DRB Application No.: 08DRB-70211

Project Name: HUBBELL HEIGHTS

DEVELOPMENT REVIEW BOARD MEMO

**CITY OF ALBUQUERQUE
PLANNING DEPARTMENT
May 14, 2008
DRB Comments**

**PLAT OF  
 LOTS 7-A AND 8-A  
 HUBBELL HEIGHTS**

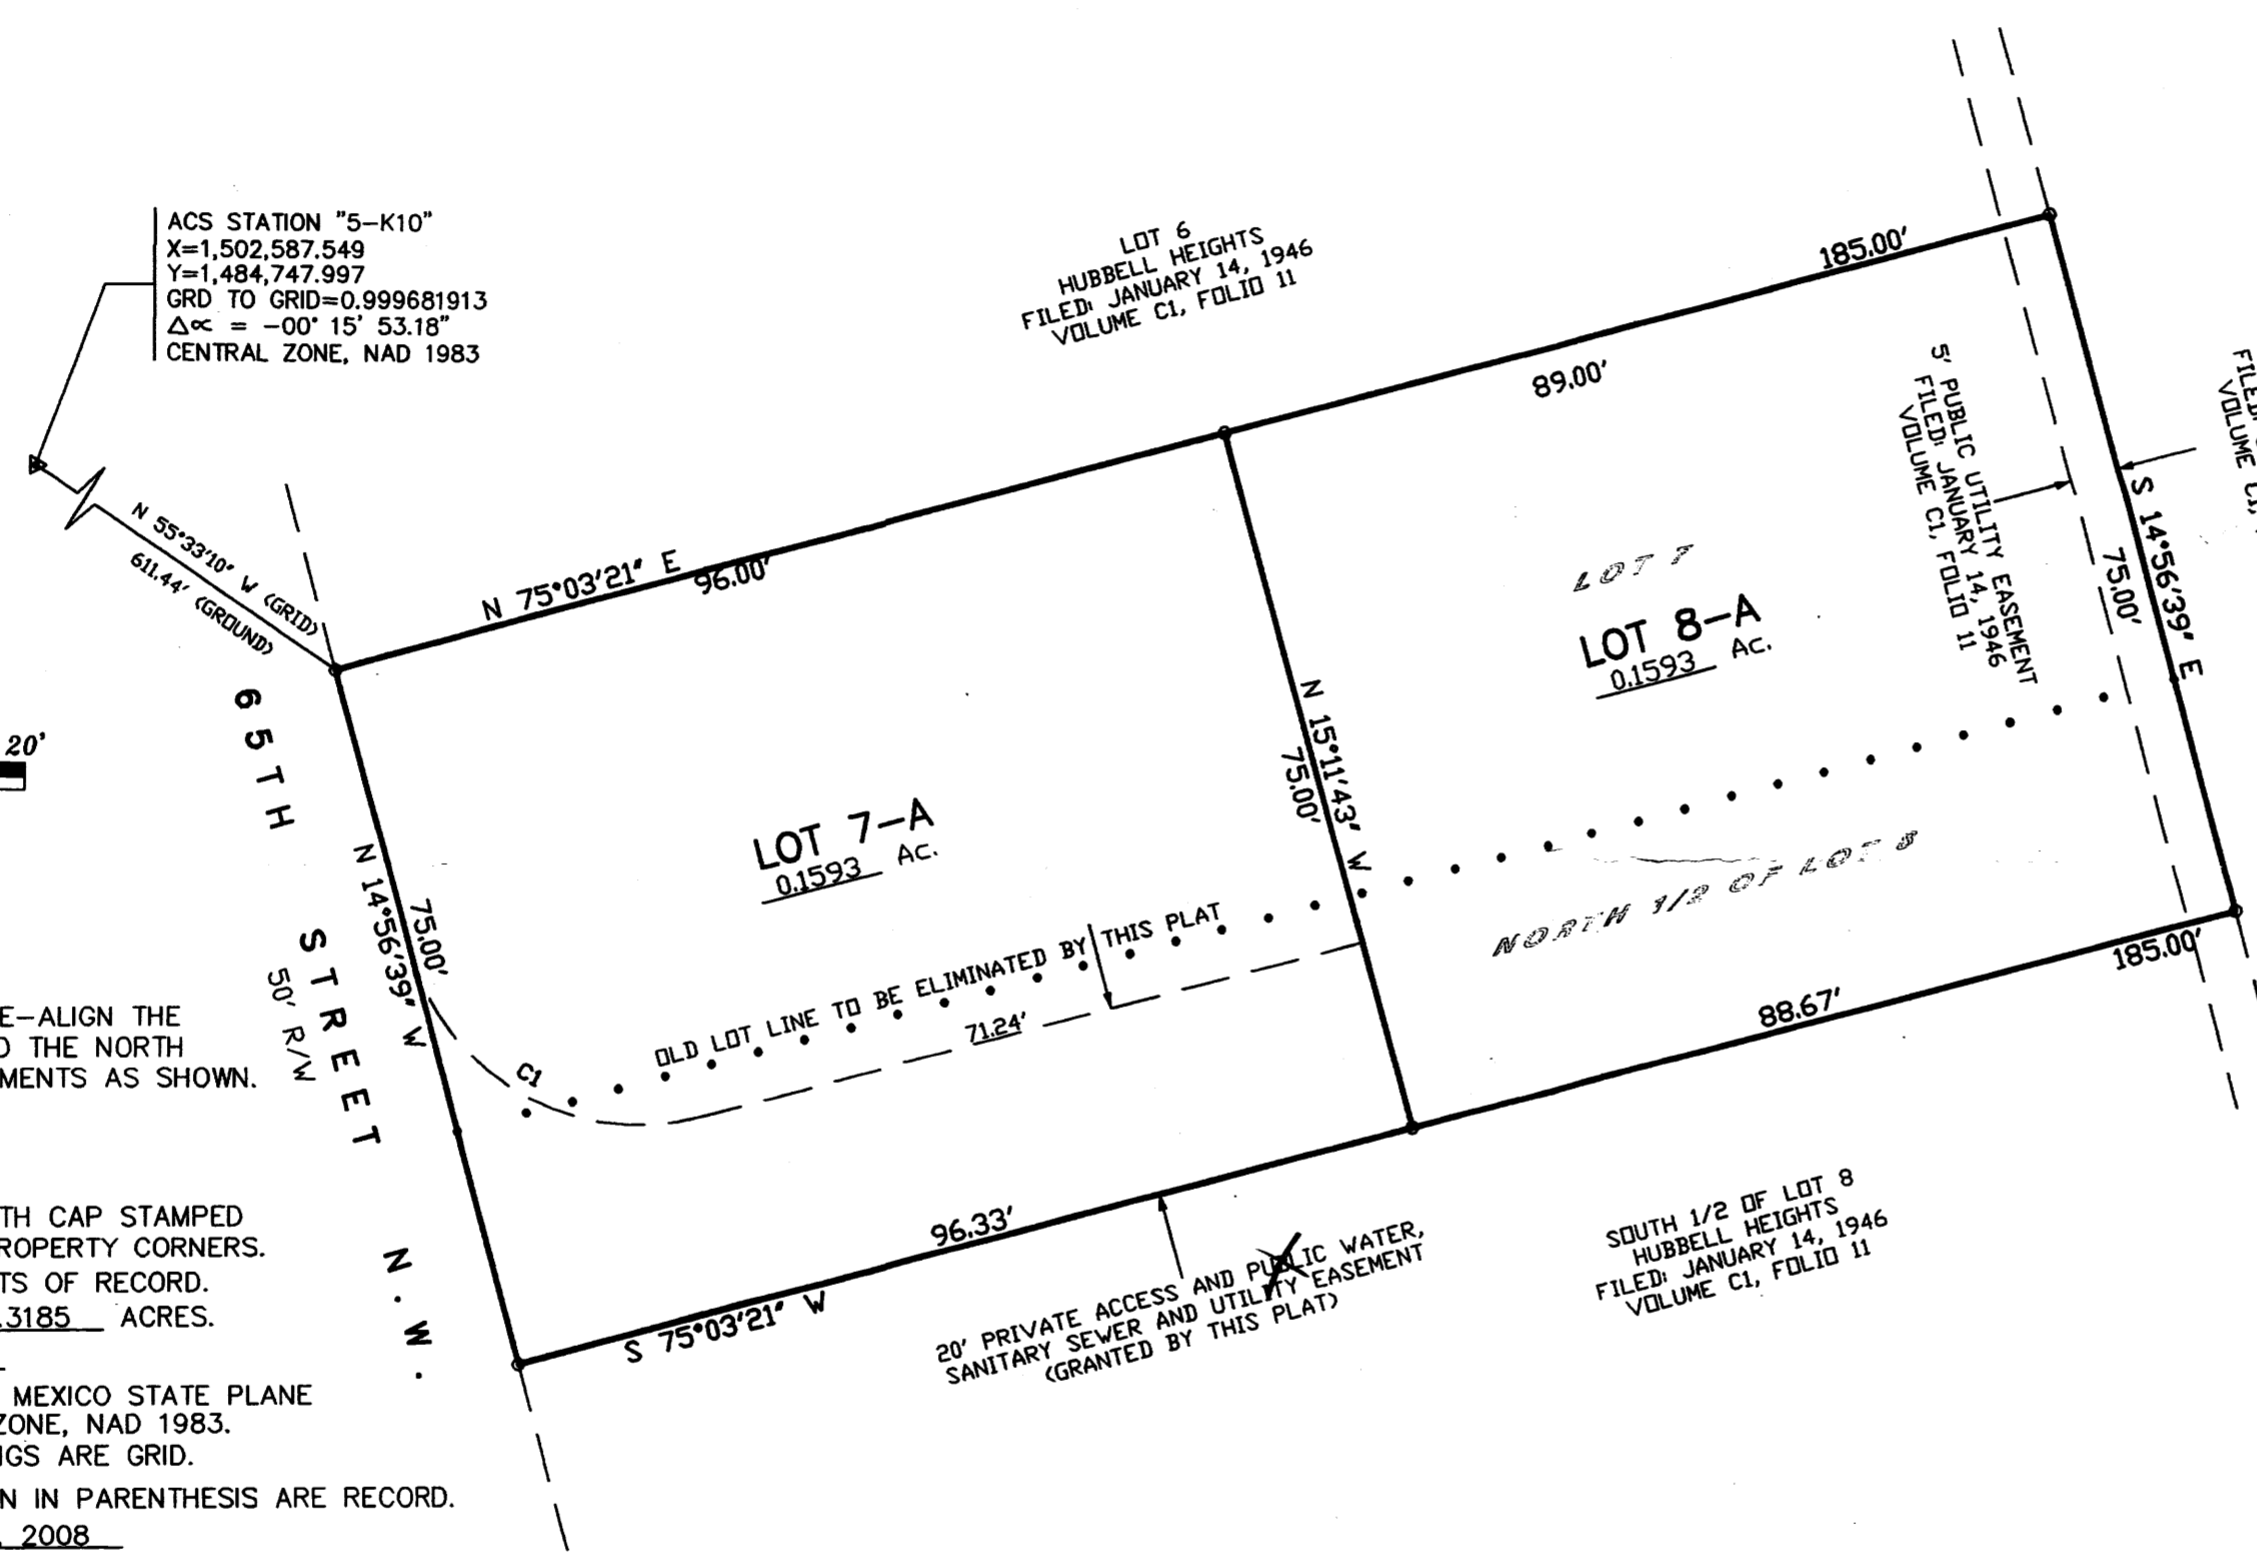
f 3-08
*PLANNING (Last to sign): - Met lot area; private E'ment
- AMAFCA; Drainage; add Maintenance & Beneficiary*

A drainage easement is required.

Net lot area (exclusive of access easement - minimum 5,000 sq ft) needs to be noted on the plat. For future reference, please do not identify the property's zoning (Note 9) on the plat.
